**WEST SUSSEX COUNTY COUNCIL
STRATEGIC PLANNING CONSULTATION**

SUBJECT: P/94/15/PL - 3 No. detached bungalows with garage, parking & deck (resubmission following P/12/15/PL).

Land to east of 29 Harbour Road, Pagham, PO21 4TF

Location Plan

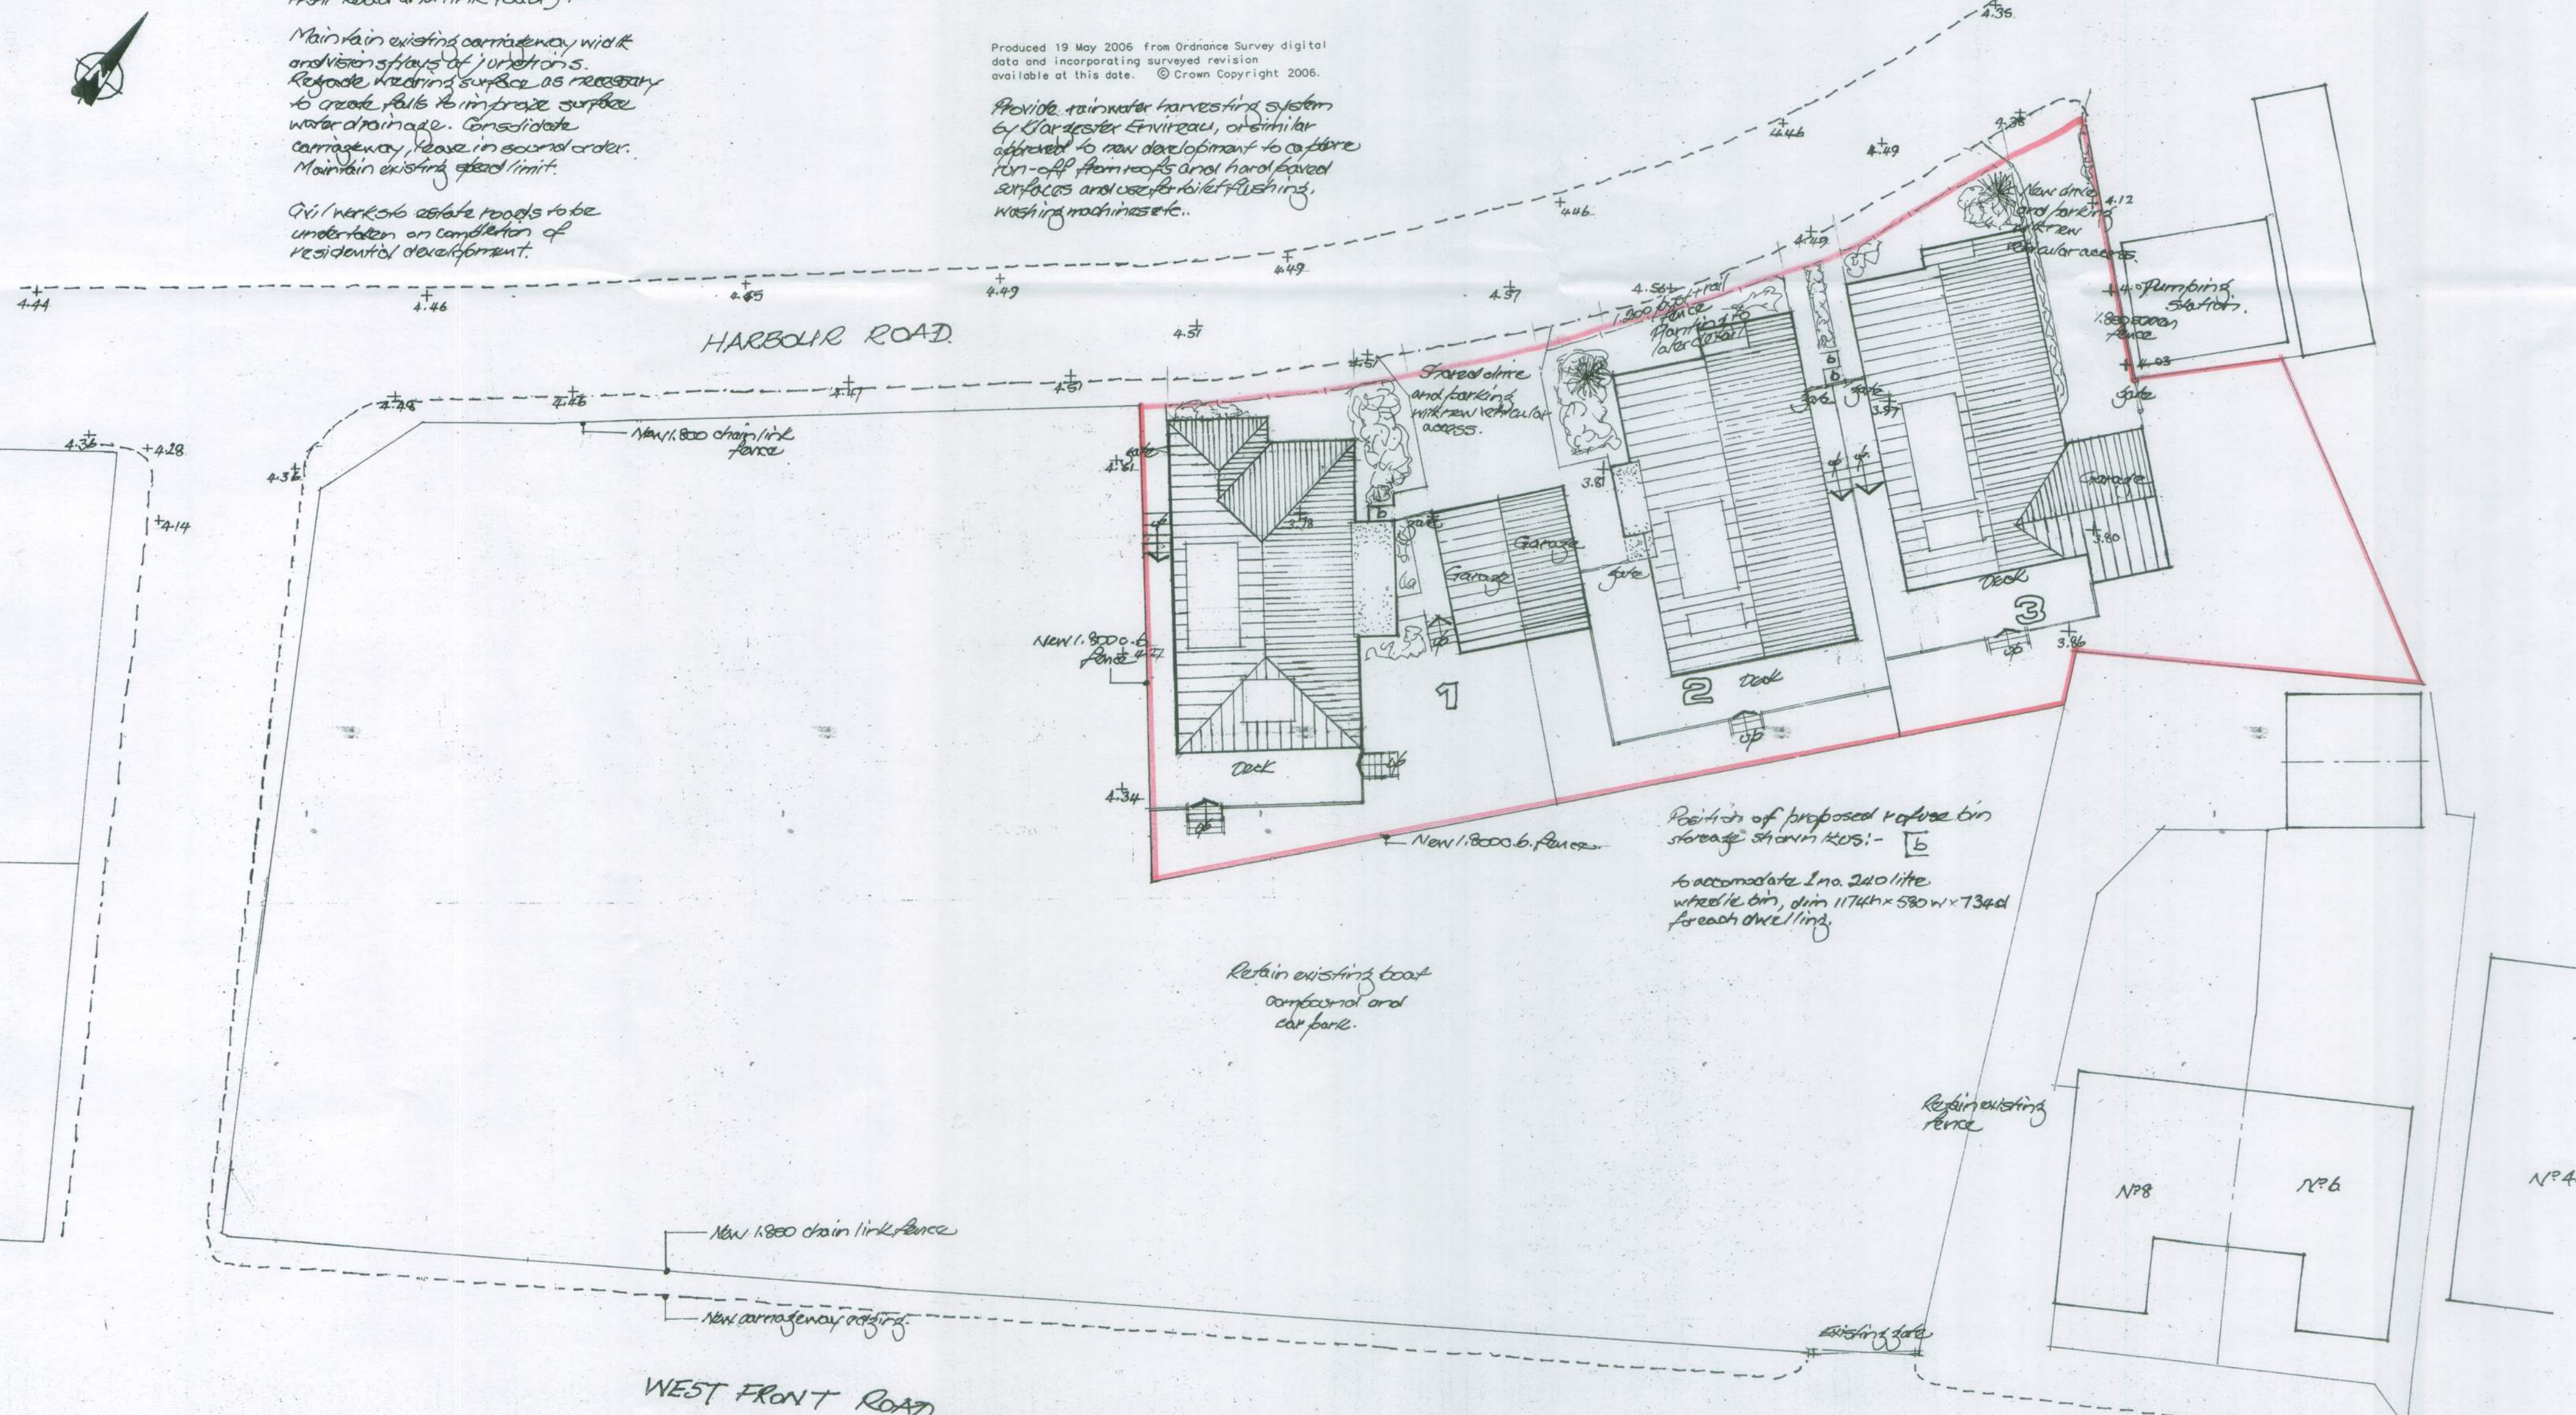
The LHA can only offer advice for this application as Harbour Road is a private road and does not form part of the adopted highway network. The application proposes two new accesses to the site, one for property 3 for single use and one for properties 1 & 2 as shared use. Both accesses would appear to meet requirements, although no visibility displays have been provided with the application.

From an inspection of the plans there is no space provided on site for vehicles to turn and exit onto Harbour Road in forward gear, so vehicles would be reversing out or into the accesses which is not ideal, however it would appear that a vehicle traveling along Harbour Road would have good forward visibility should this happen and vehicles would be traveling at low speeds along Harbour Road due to the road's surface, allowing time to stop.

In terms of parking the proposed 6 spaces would be adequate for this development.

Cycle parking should be included; this must be secure, covered and be capable of storing at least one cycle per bedroom for each dwelling. The actual details of the cycle parking facilities should be submitted to and approved by the Local Planning Authority (LPA).
